DELEGATED DECISION

Item No.	Report of the Head of Planning, Transportation and Regeneration
Address	LAND AT 30 - 32 CHESTER ROAD NORTHWOOD
Development:	Development of 29-bed Residential Care Home, alterations to access, to vehicular crossover and associated landscaping.
LBH Ref Nos:	13800/APP/2019/604
Drawing Nos:	SCH0718-13 SCH0718-15 SCH0718-14 SCH0718-02 SCH0718-03 SCH0718-04 SCH0718-05 SCH0718-06 SCH0718-07 SCH0718-08 SCH0718-09 (Rev.1) SCH0718-10 SCH0718-11 SCH0718-12 SCH0718-01

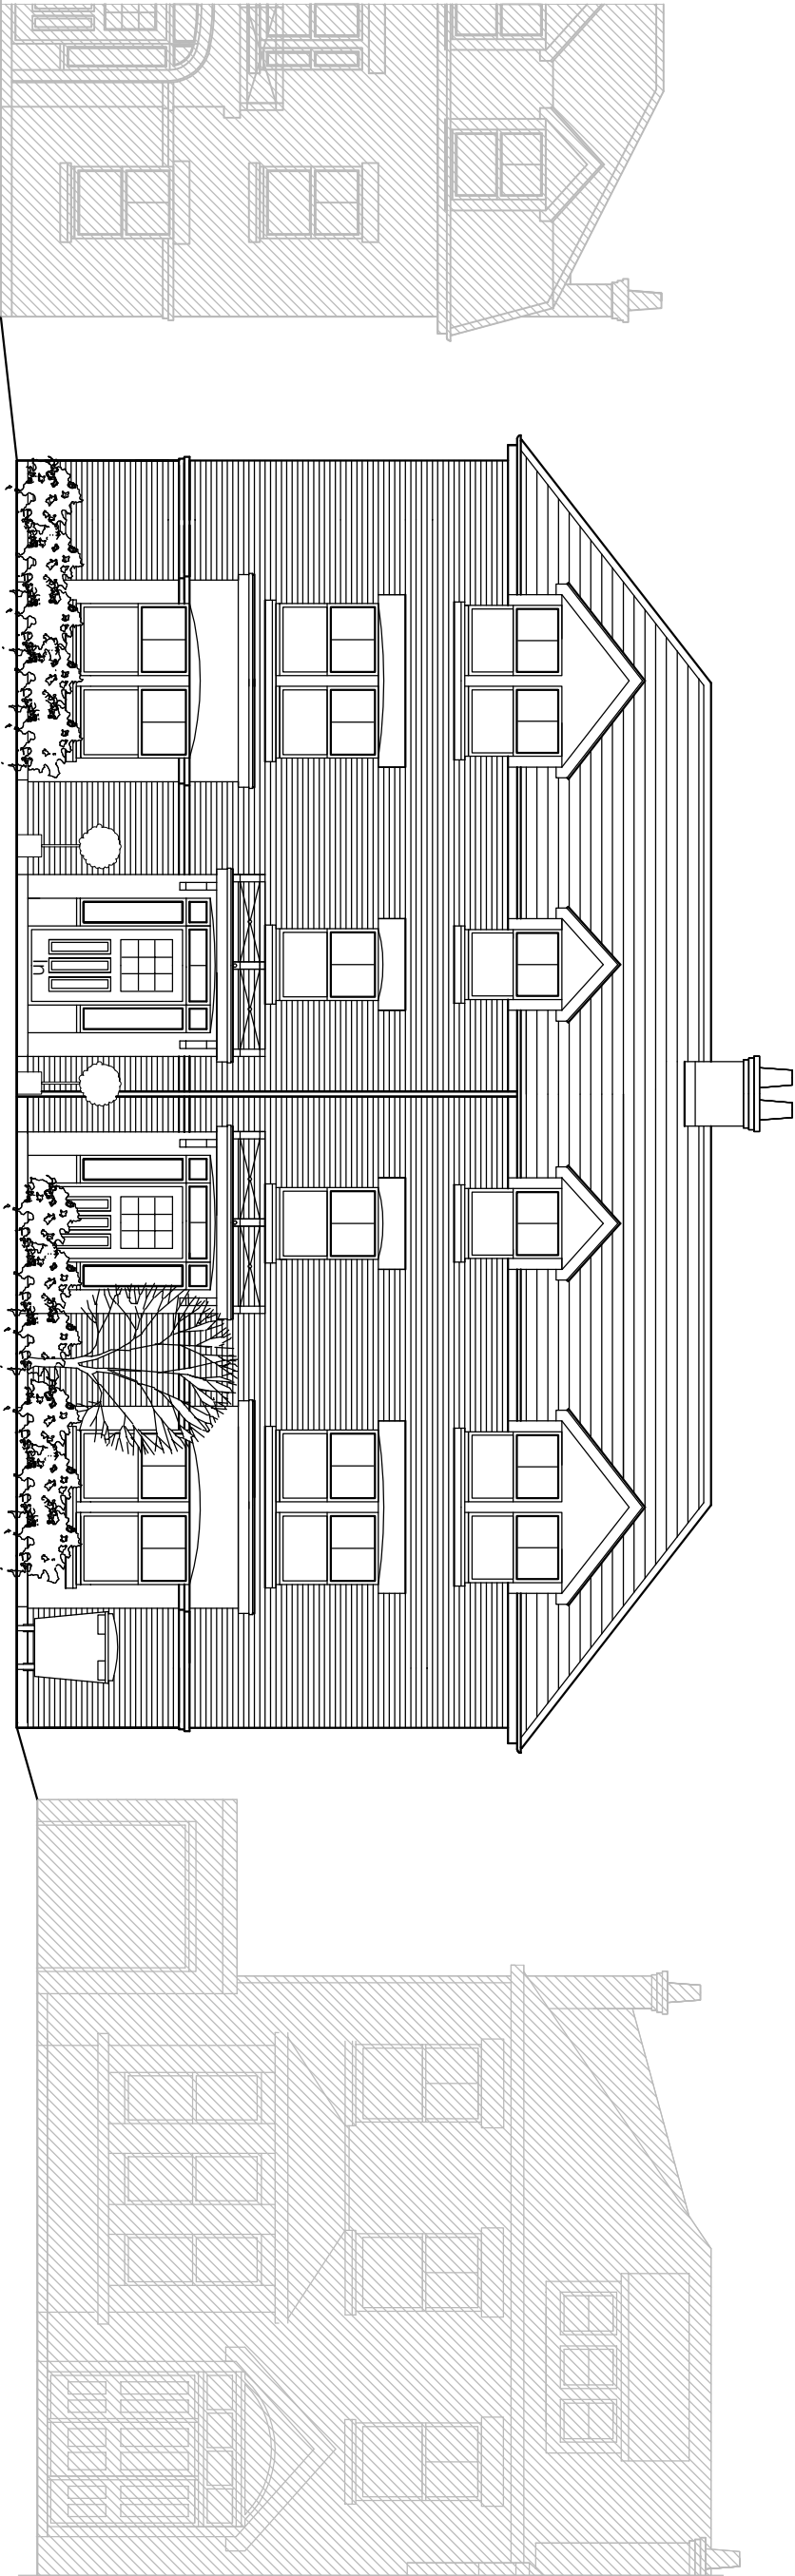
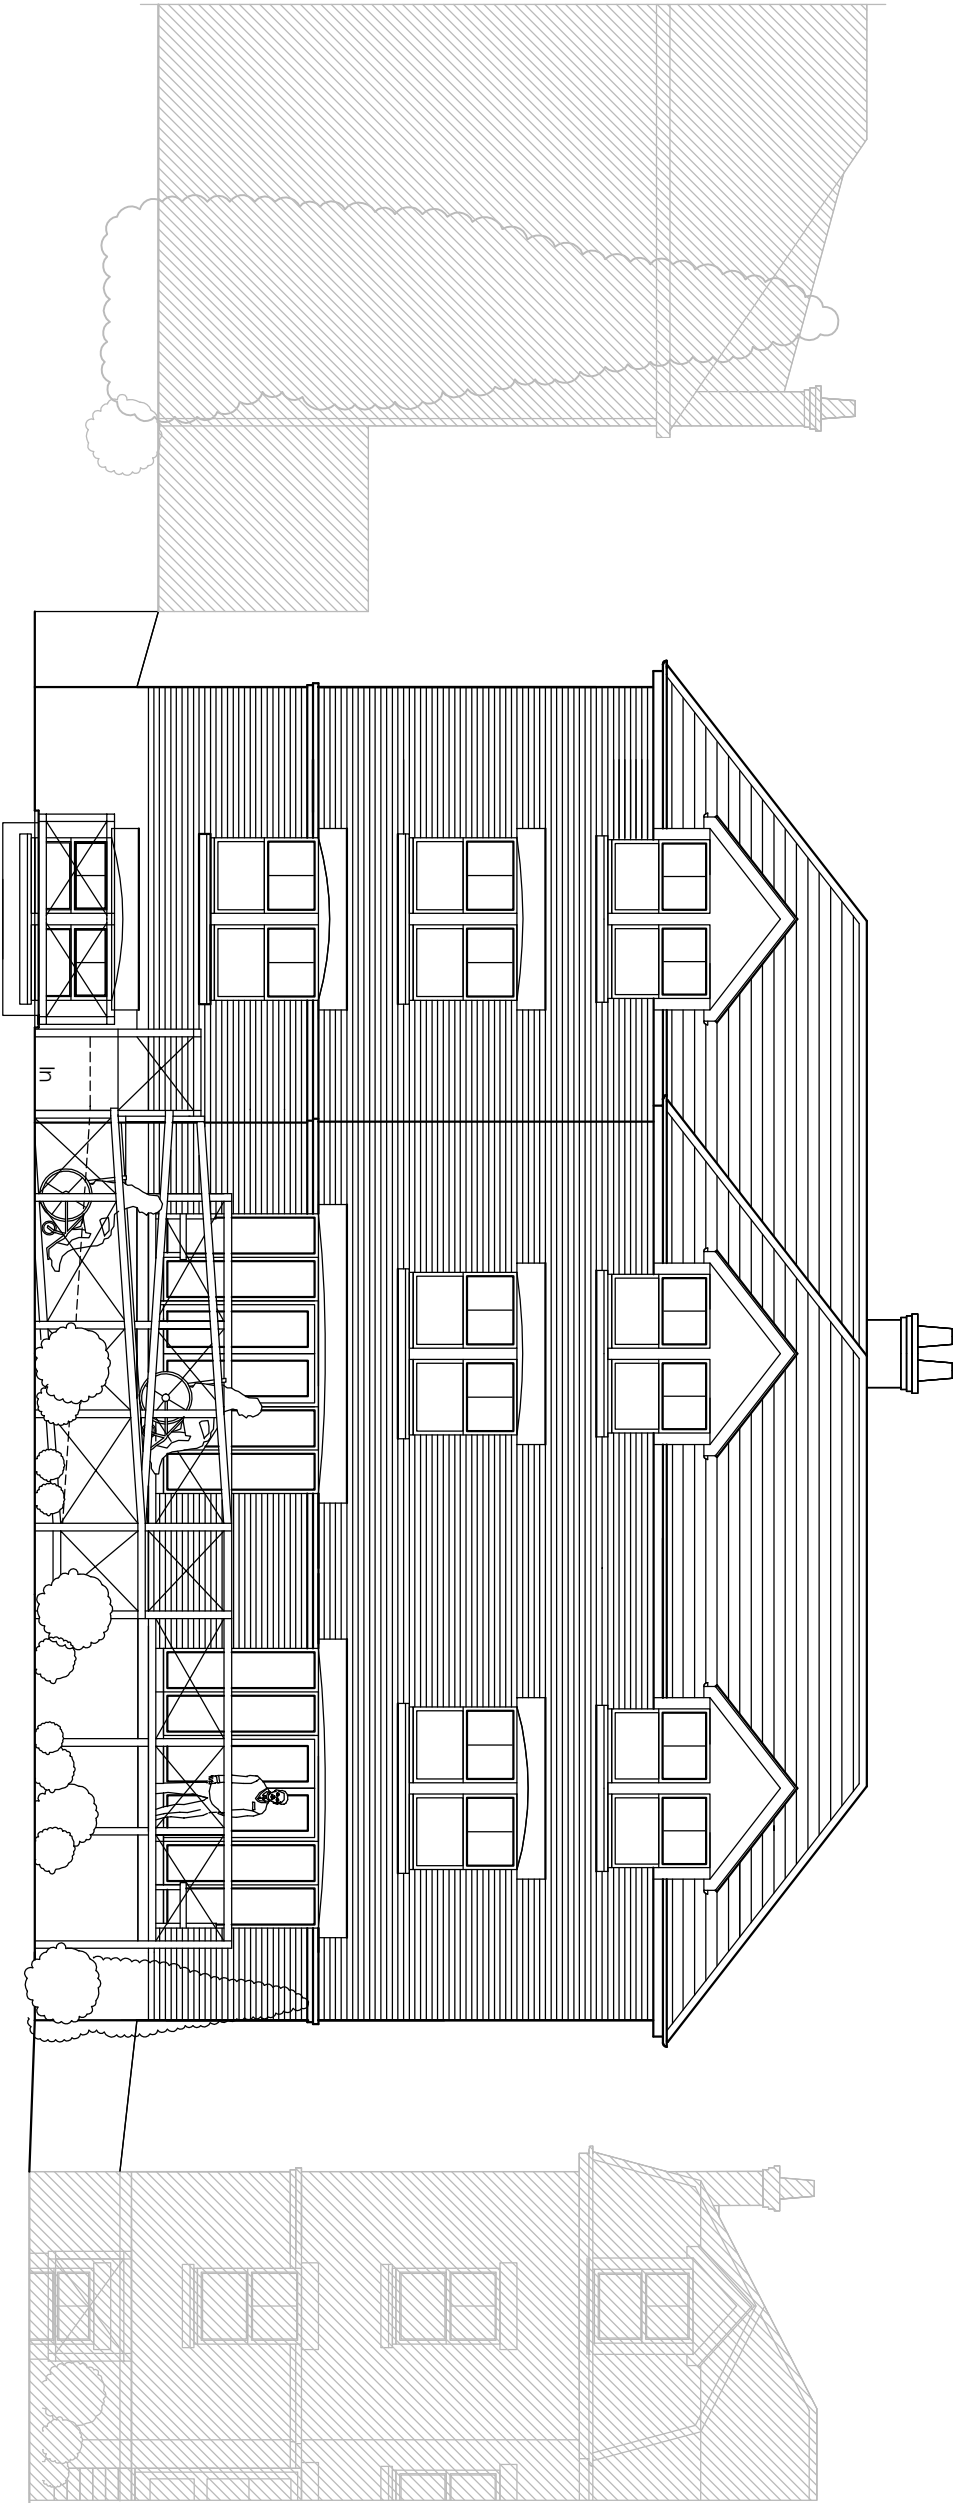
In comparison to the previously approved scheme at no. 30-32 Chester road (ref.13800/APP/2011/1140), the proposed scheme is considered to have a detrimental visual impact on the street scene when viewed from Chester road. The proposed increase in the width of the dormer windows would alter the overall appearance as would the relocation of the dormers to lower in the roof space. The design of the roof and in particular the pitch has altered since the previous permission to the detriment of the overall appearance of the building.

The roof design has changed since the previous permission (ref.13800/APP/2011/1140) as well as the size and location of the proposed dormers. Two of the four dormers in the front elevation are larger in terms of width and all are positioned lower in the roof. The pitch of the roof has also changed and appears steeper.

There are concerns with the increase in bulk of the building. The consented scheme is already large and the proposals will increase its presence on the street. The increase in height of the brick elevations with the dormers breaking through the eaves line would be an incongruous element that would put more emphasis on the second floor at odds with the established character of the street scene where the dormers are contained on the roof slopes.
